Design & Access & Planning Statement

No 50 Don Street, Springvale. S36 6HA

With regards to the enquiry (ref: 2018/enq/00158) at 50 Don Street, Springvale.

Drawing Title: Site Plan - Proposed

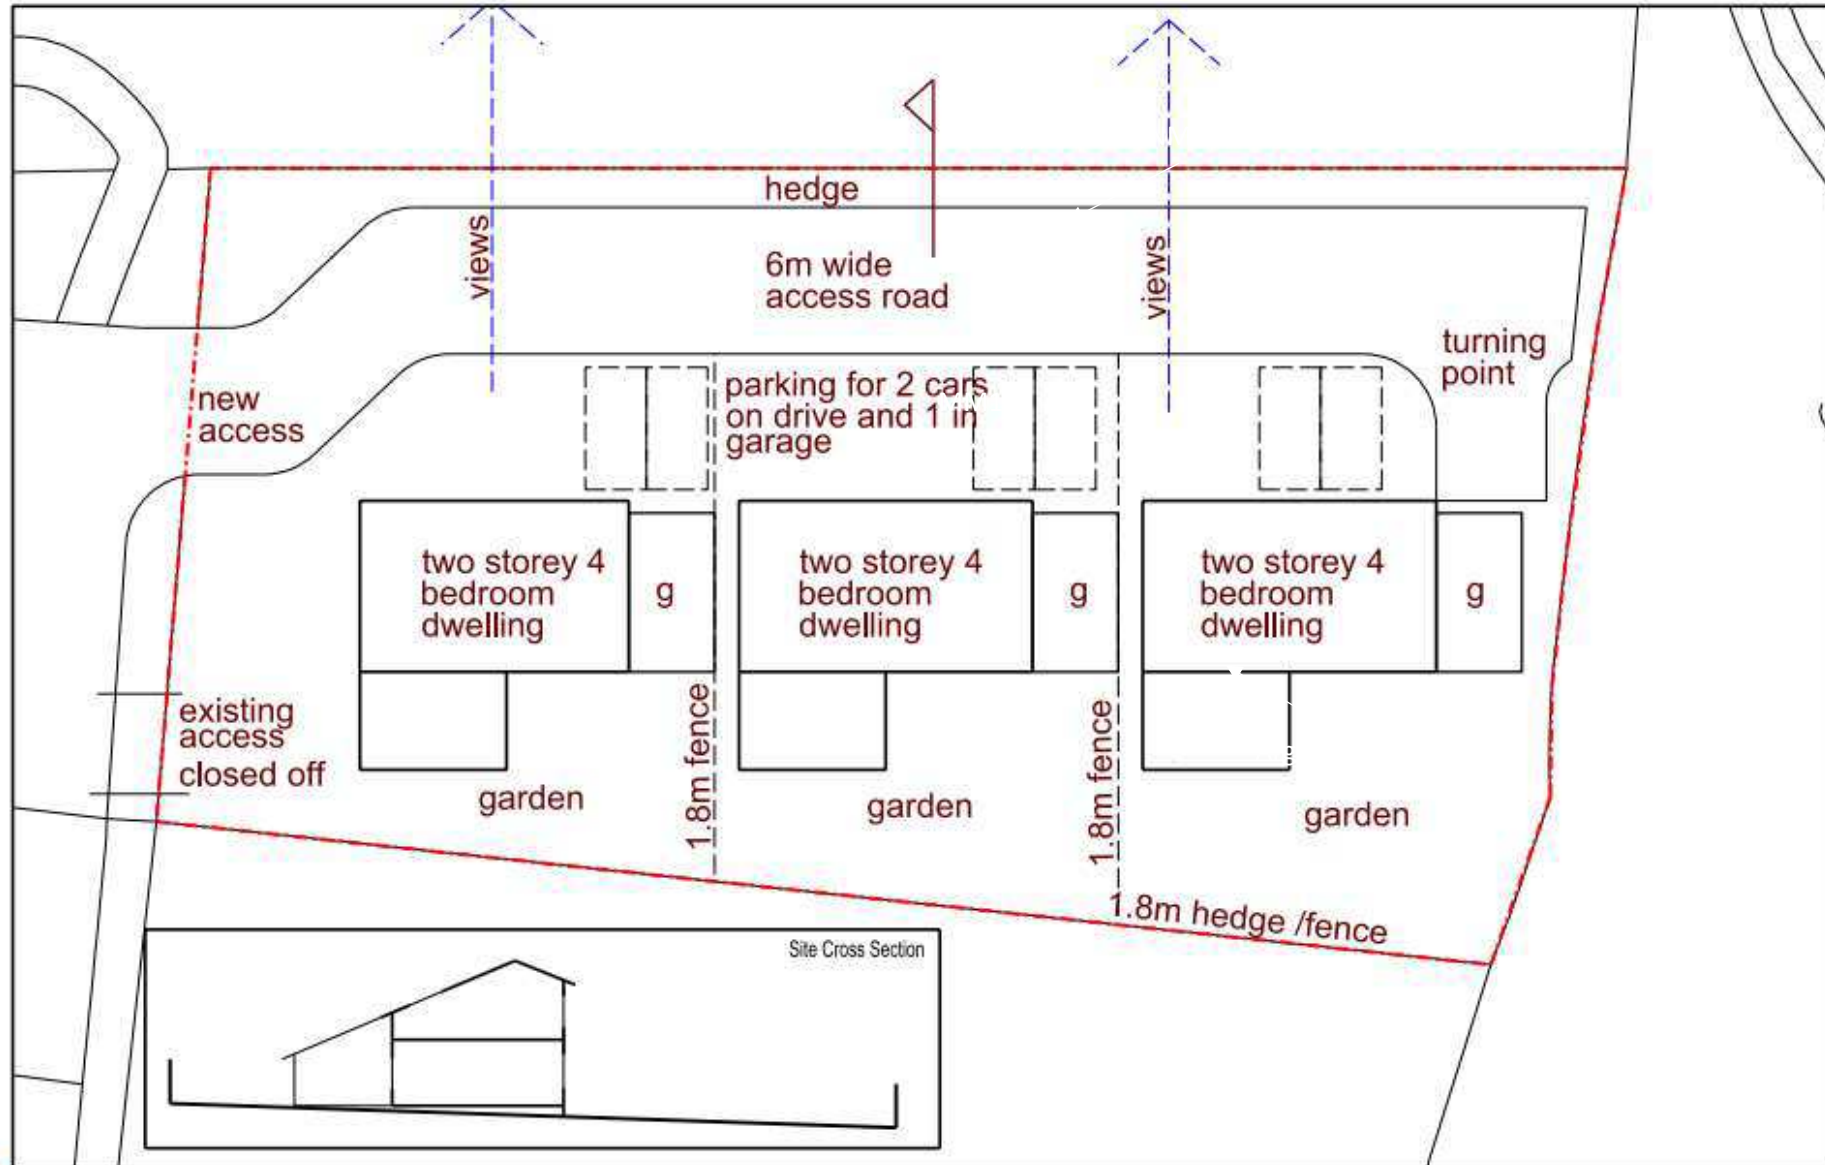
The design proposed appears to be similar to the existing dwelling and the wider streetscene does appear mixed in character, therefore, from the information provided I think this could be acceptable. The orientation of the properties is at odds with the wider street however and I would need more information as part of an application in order to fully assess if this is acceptable. I would also refer you to our SPD on Designing New Housing Development (attached) when finalising any plans.

The section of Don Street fronting the enquiry site is not an adopted highway; it is a private street. This section does not have any footways and one would be required fronting the whole site frontage, to tie-in with the existing adopted footway, in the interest of highway safety.

The proposed access is an acceptable width but the turning head appears narrow and it would need to be proved that it was capable of accommodating the turning manoeuvres of a fire appliance, in the form of a drawing showing the swept path of the vehicle, as the properties exceed the carry distance.

An area shall be set aside adjacent to the highway but within the red line site boundary, for the storage of waste bins and waste recycling bins on bin collection day.

Any gates must be hung so as to open inwards into the site and not out onto the access.

Comments from the planning officer are included below, the suggested amendment have been made to the submitted plans, including the footpath and turning circle and the acoustic report. The orientation of the dwelling fronting Don Street has been rotated to address Don Street so resolving the officers.

A new access onto an un-adopted highway is required, this will be asphalted and a footway provided all to match into the adopted highway to the south, the access road will provide a turning area suitable for a fire appliance in line with regulations.

Refuse & recycling area is provided to the side of each property and an area set aside off Don street for storage during weekly collection
